Appeal Decisions

2 Linksway, Northwood HA6 2XB

Appeal A: APP/R5510/C/17/3172497

Appeal B: APP/R5510/D/17/3176155

AS BUILT PLANS & ELEVATIONS

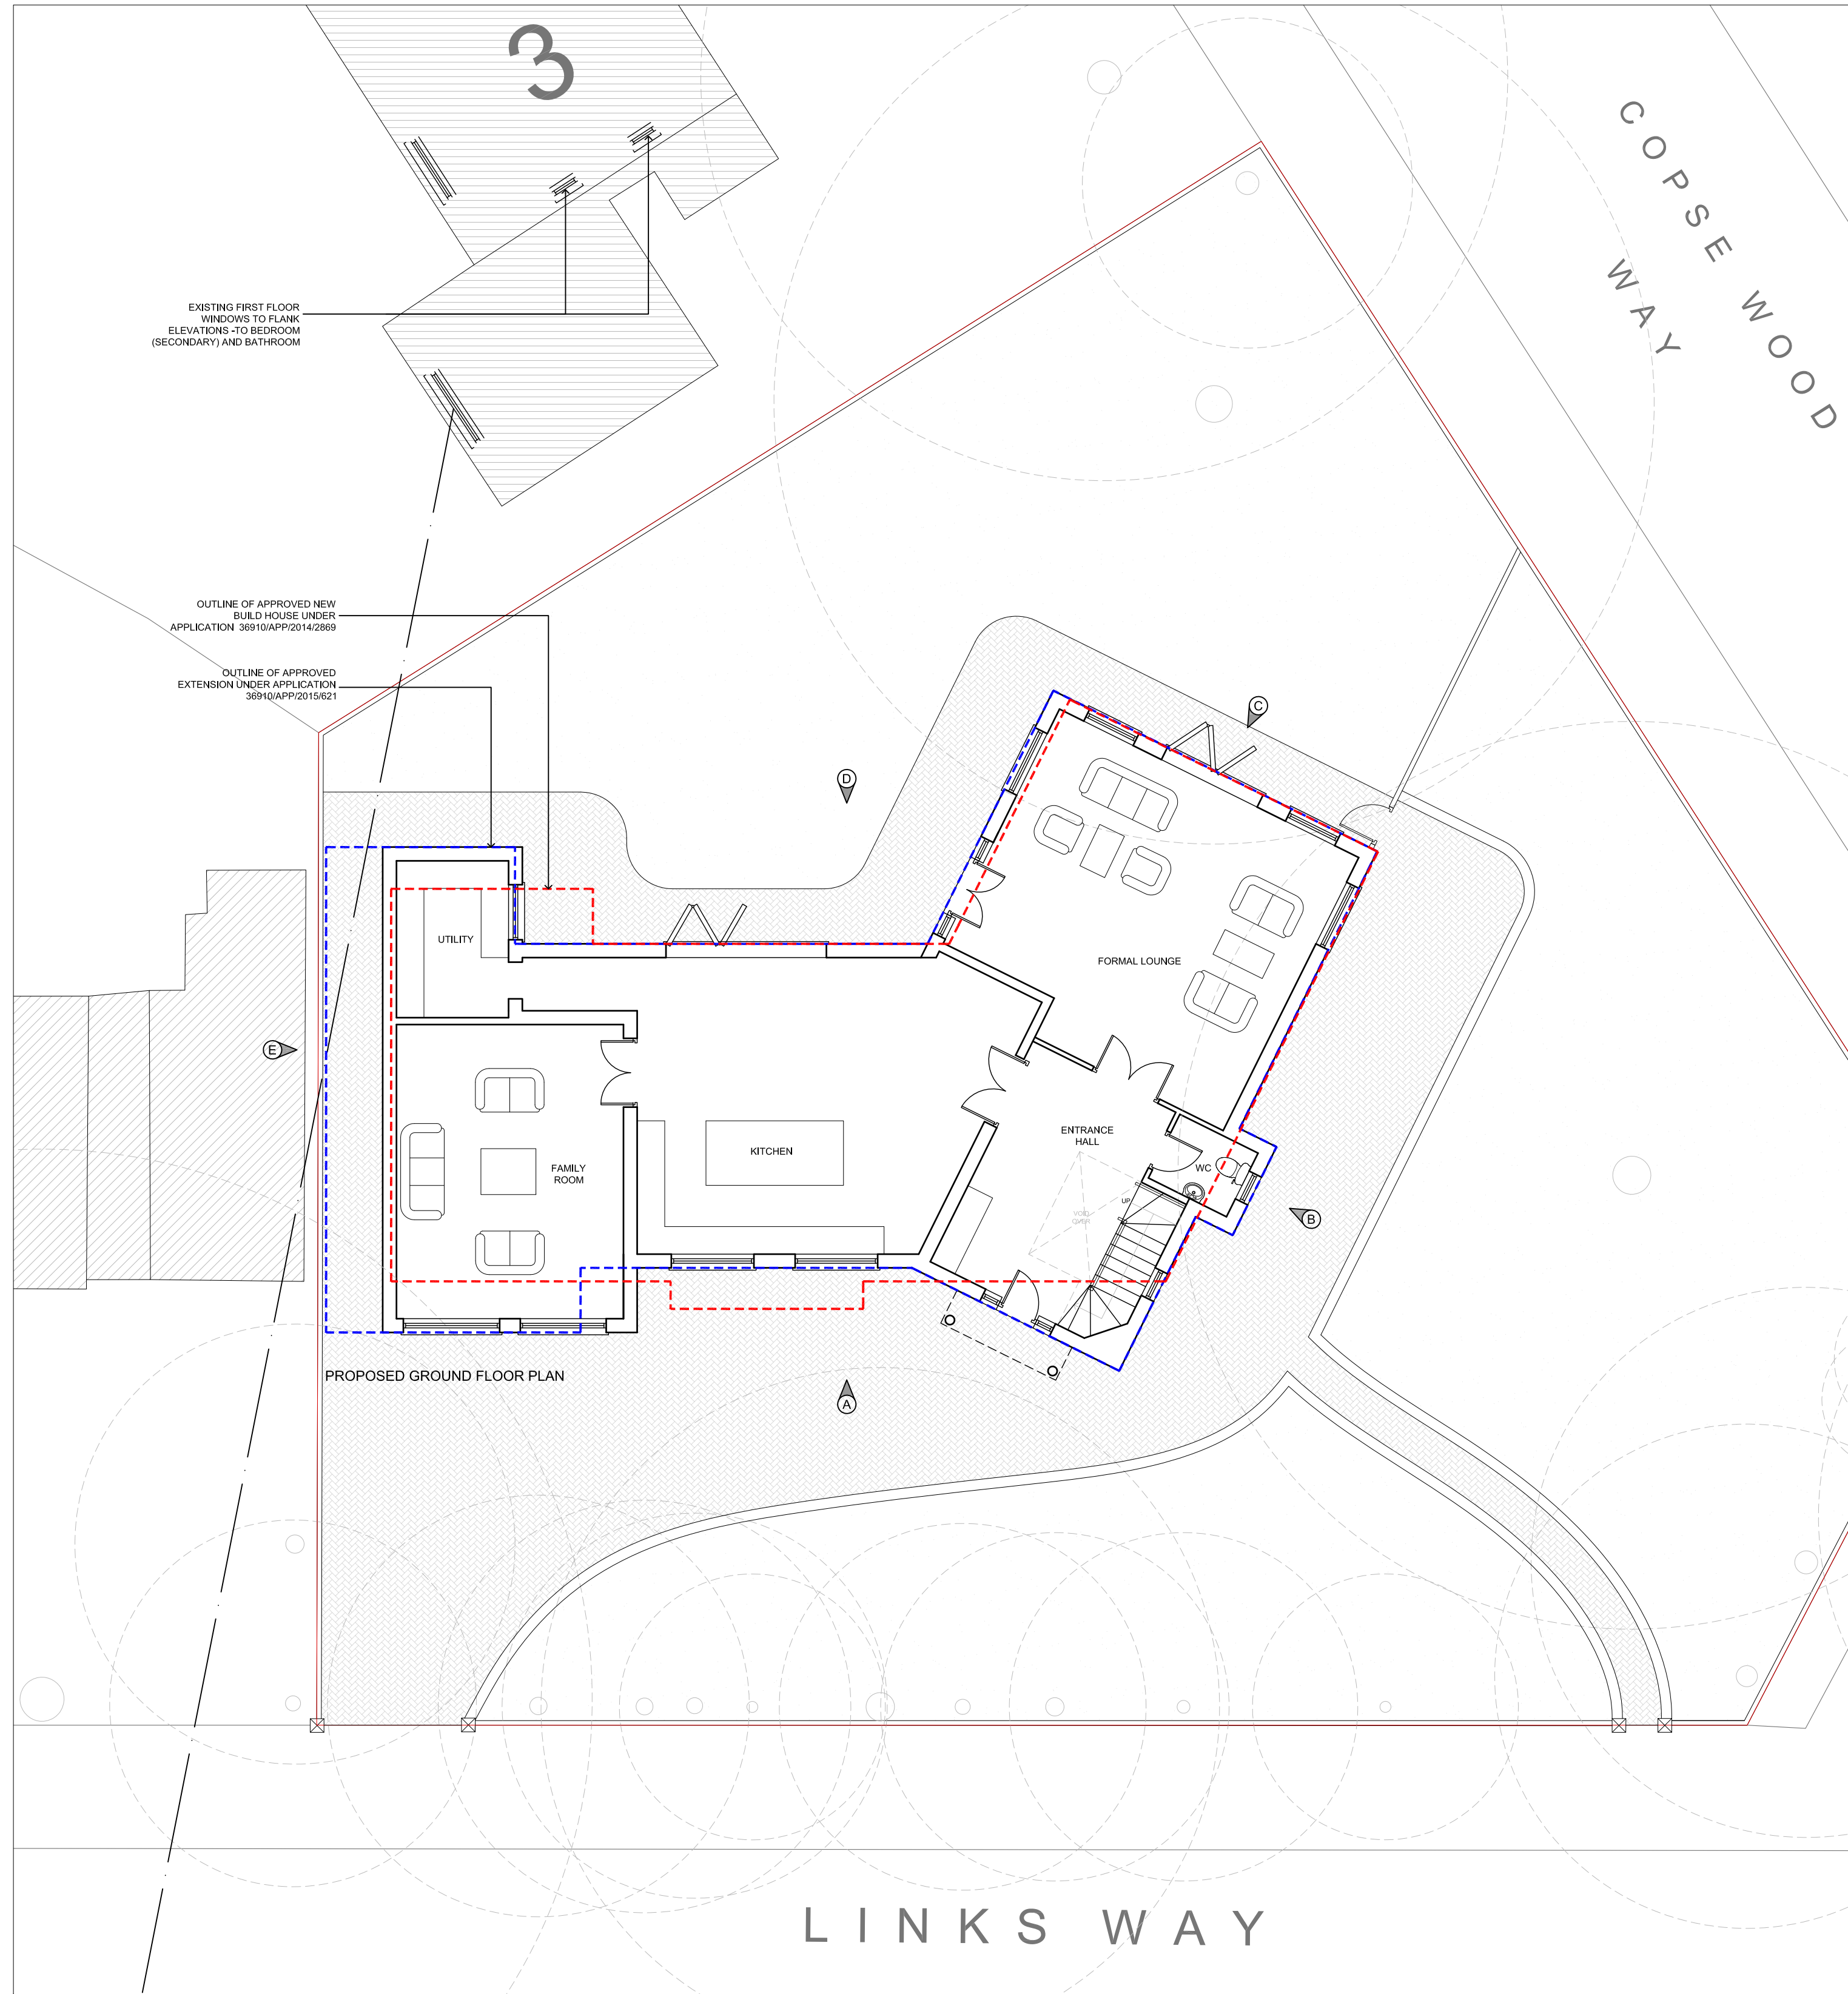
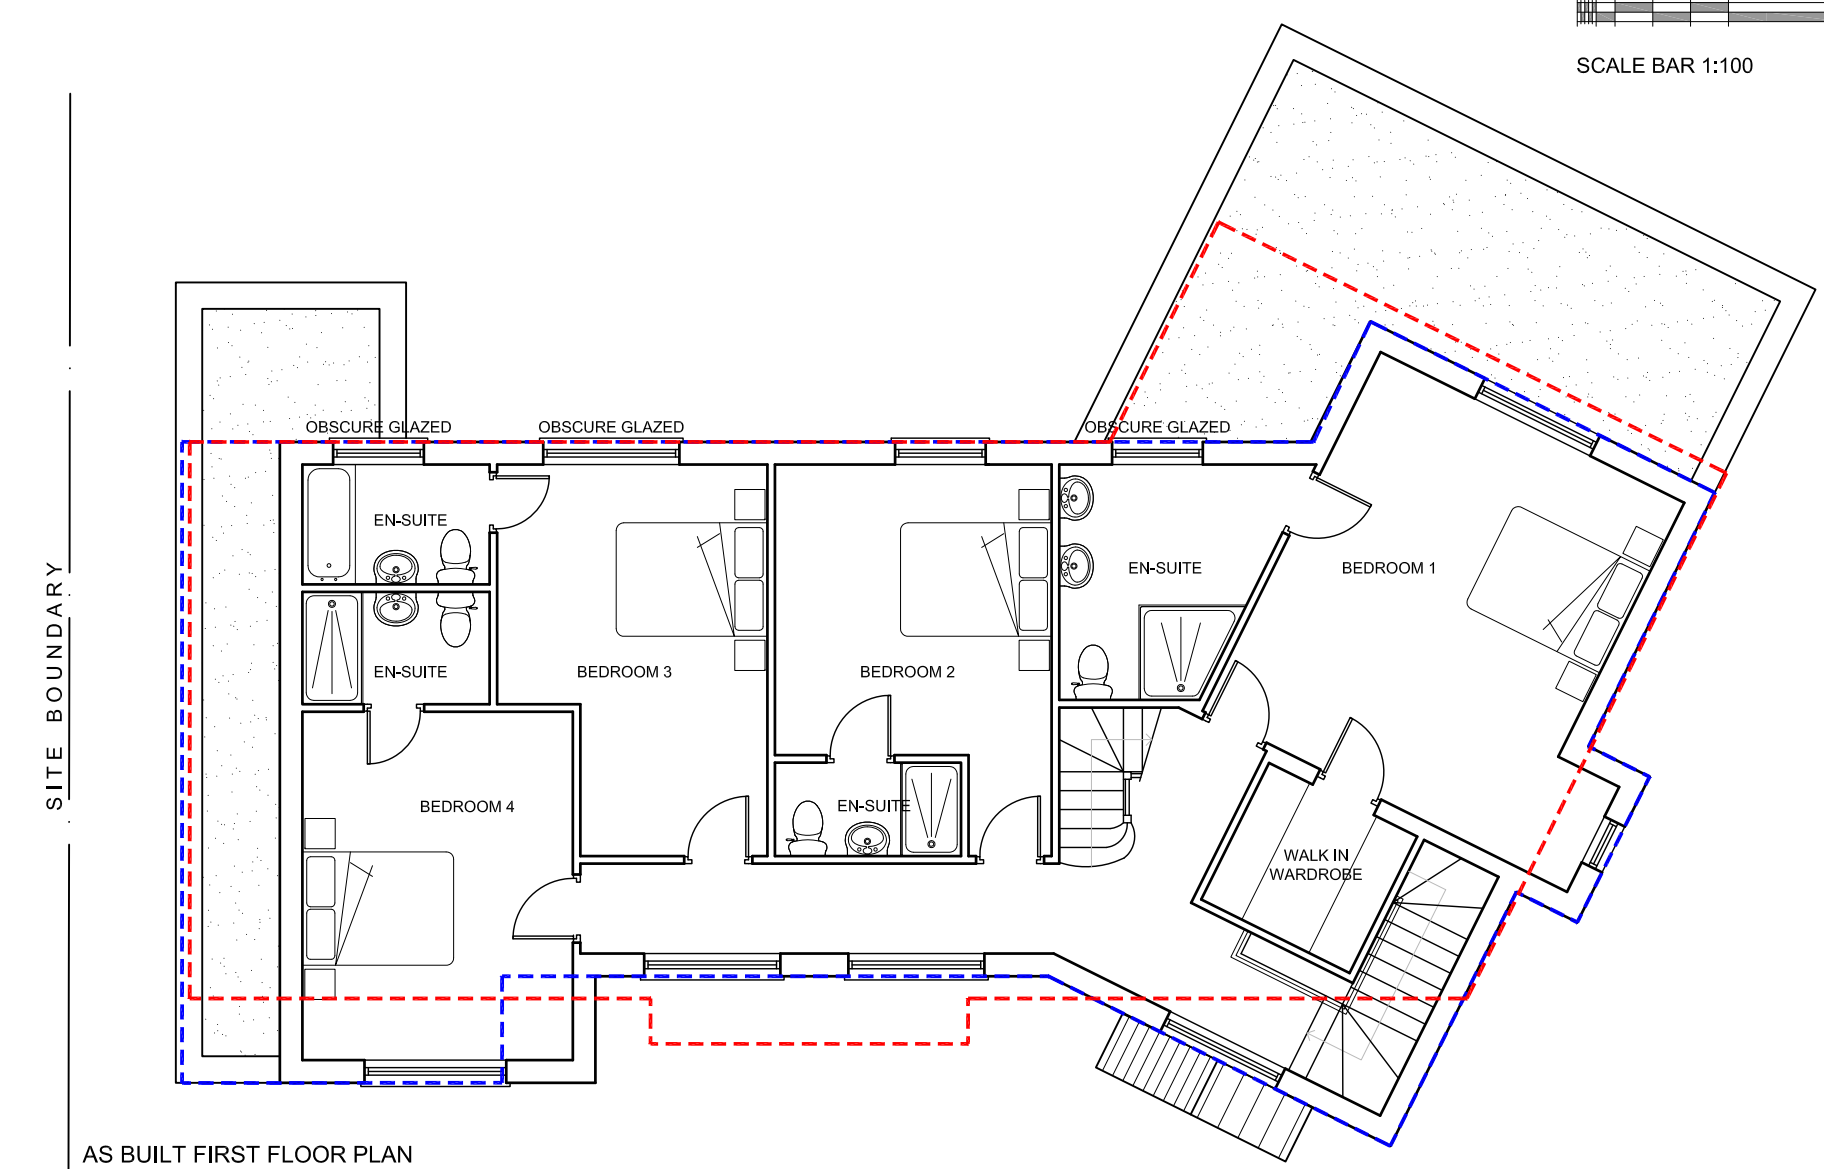
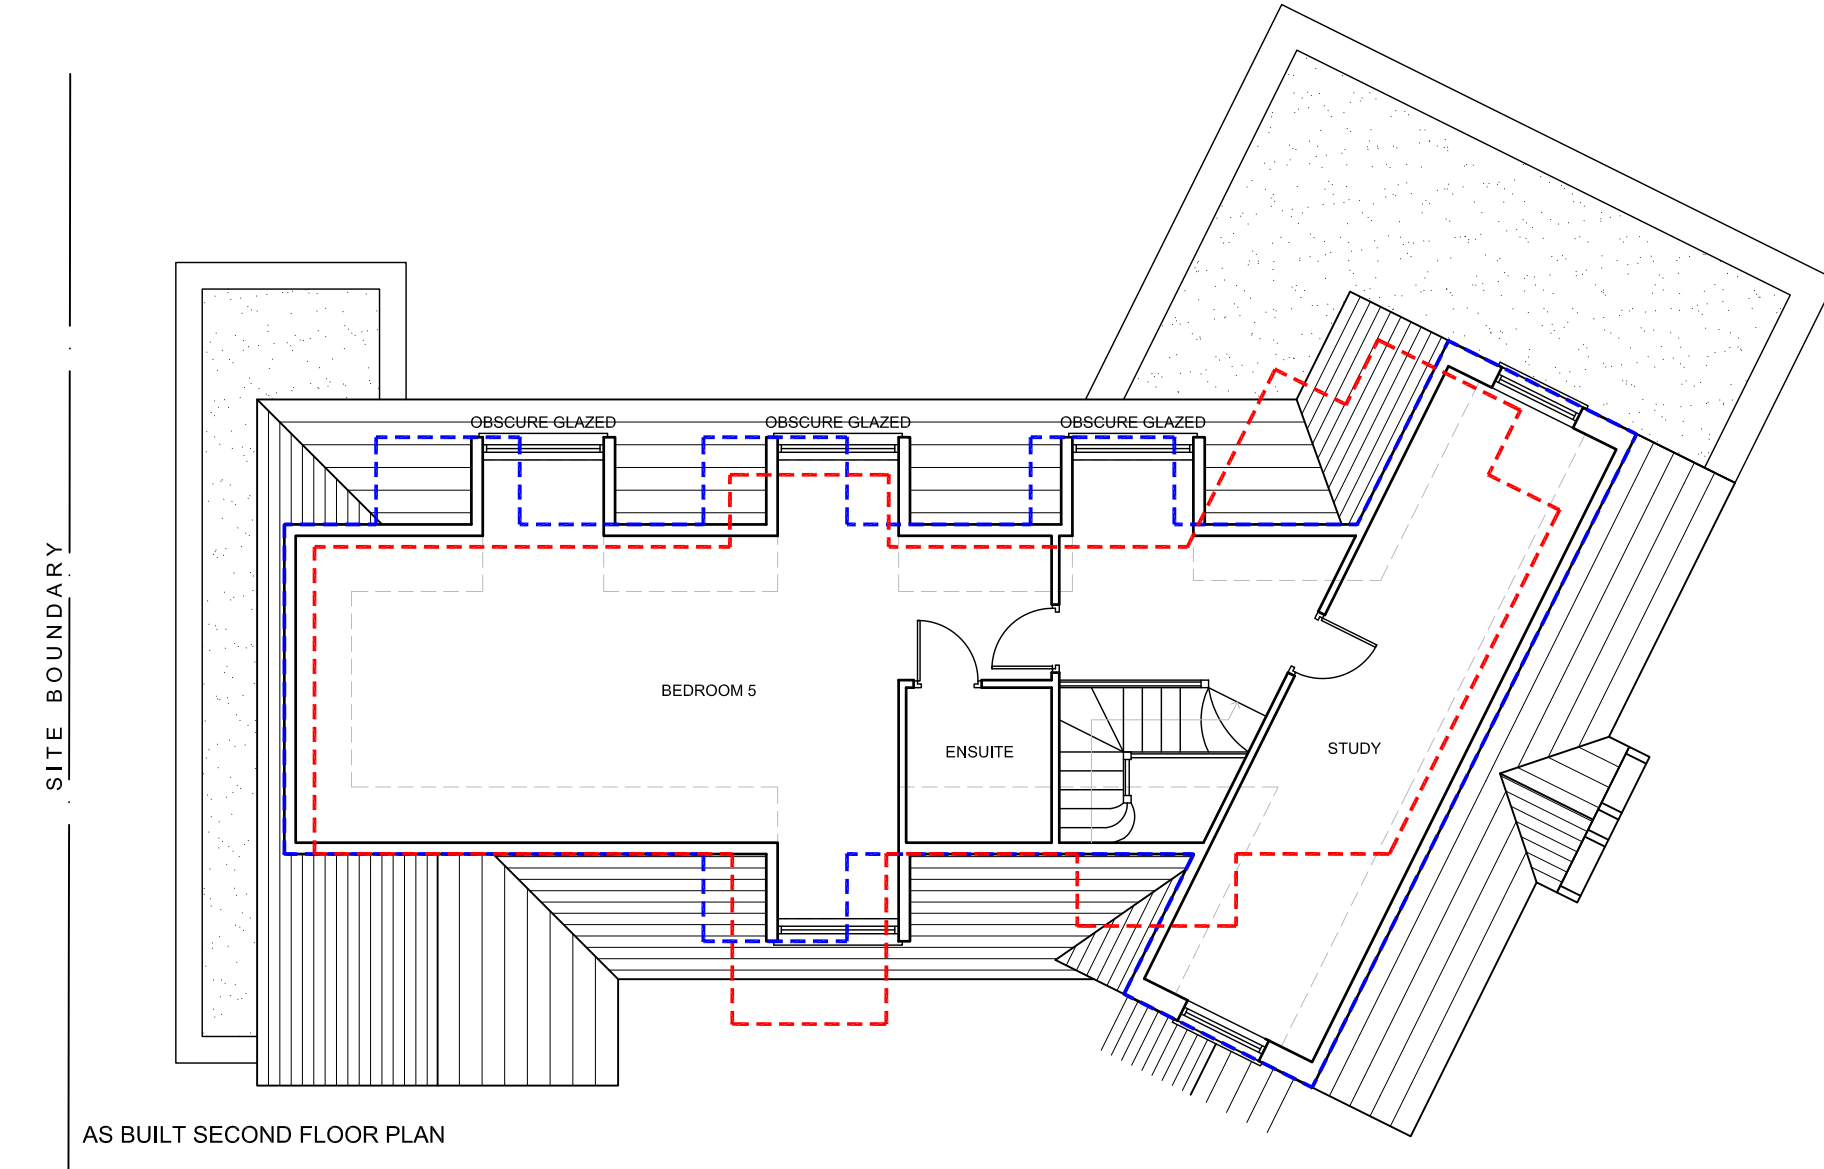
8. The parties agree that the main differences between the approved and built development are (i) the extended property has been stepped in from the southern side boundary (ii) the eaves height of the main roof has been raised by 0.825m to 5.4m (iii) the ridge height has been raised by 0.335m to 8.95m (iv) the rear facing dormer windows now all serve a bedroom (v) first floor windows have been altered and enlarged (vi) the height of the flat roofed single storey element has been raised and incorporates a parapet wall.
9. Internal changes have been made to the layout from that approved with consequential alterations to the exterior. There is an enlarged fifth bedroom which is served by all of the rear facing dormer windows instead of one window with the others serving an en-suite bathroom and storage space. Temporary obscured glazing has been undertaken to some windows.

14. Now that the eaves are raised, the proportions of the property have altered in consequence. The height of the vertical walls has increased leading to larger areas of blank wall. The roof is also shallower than the scheme approved because the ridge height has not increased to the same degree as the eaves. The single storey element to the side and rear is also higher and incorporates a parapet wall. These may be notable differences between the two sets of plans, but when viewing the property from the street or rear garden, they are not particularly significant in terms of visual impact. The roof does not appear unusually shallow in the context of its surroundings or cause the roof dormers to seem overly pronounced. Nor does the side extension appear disproportionate to the rest of the dwelling.

22. The internal reconfiguration has resulted in a second roof dormer serving a bedroom instead of a bathroom. There is also a larger bedroom window on the first floor where there would have been an en-suite bathroom. These first and second floor level windows face towards the boundary with neighbouring No 3 Copse Wood Way. Its flank wall is estimated to be around 10m away.

23. Plastic film has been attached to some upper rearward facing windows and retaining straps fitted to restrict their opening. Clearly, these measures could be removed easily at any time. If that were to happen then there would be direct views of the rear garden of No 3 at quite close range even though the first floor bedroom (identified in the plans as 'bedroom 3') is further away from the shared boundary than previously approved.

24. Indeed, whilst there was opaque film stuck to the first floor en-suite bathroom for bedroom 3, the bedroom window itself was clear glazed. The patio closest to the house at No 3 was visible as were other parts of the garden. This is overly intrusive given the size, position and distance of the window to the neighbouring rear garden. It gives rise to an unacceptable interference with the privacy of neighbours using their garden. That is so irrespective of whether the approved scheme allowed a smaller (bathroom) window in a similar position without any restriction on the type of glazing.

31. It seems to me that a condition for obscured glazing and limited window openings would address the harm arising to neighbouring privacy if also imposed in relation to the roof dormers for the bedroom identified as 'bedroom 5' on the plans. I note that only one of these windows served a bathroom under the approved scheme and that no condition was imposed to ensure it was

obscured glazed. Nevertheless, both windows are at a height, orientation and proximity to the shared boundary so as to cause an unreasonable interference with privacy if not obscured glazed and with restricted openings.

- (i) within 3 months of the date of this decision, a scheme for the replacement of the upper floor windows identified as bedrooms 3 and 5 (including the en-suite for bedroom 3) on drawing No A203 Revision C with obscure-glazed windows to be fixed shut to an internal height of 1.7m, shall have been submitted for the written approval of the local planning authority and the scheme shall include a timetable for its implementation.

- (3) Notwithstanding the provisions of the Town and Country Planning (General Permitted Development)(England) Order 2015, (or any Order revoking, re-enacting or modifying that Order), no additional windows, doors or openings shall be formed in the walls or roof slopes of the development hereby approved on any elevation facing No 3 Copse Wood Way.
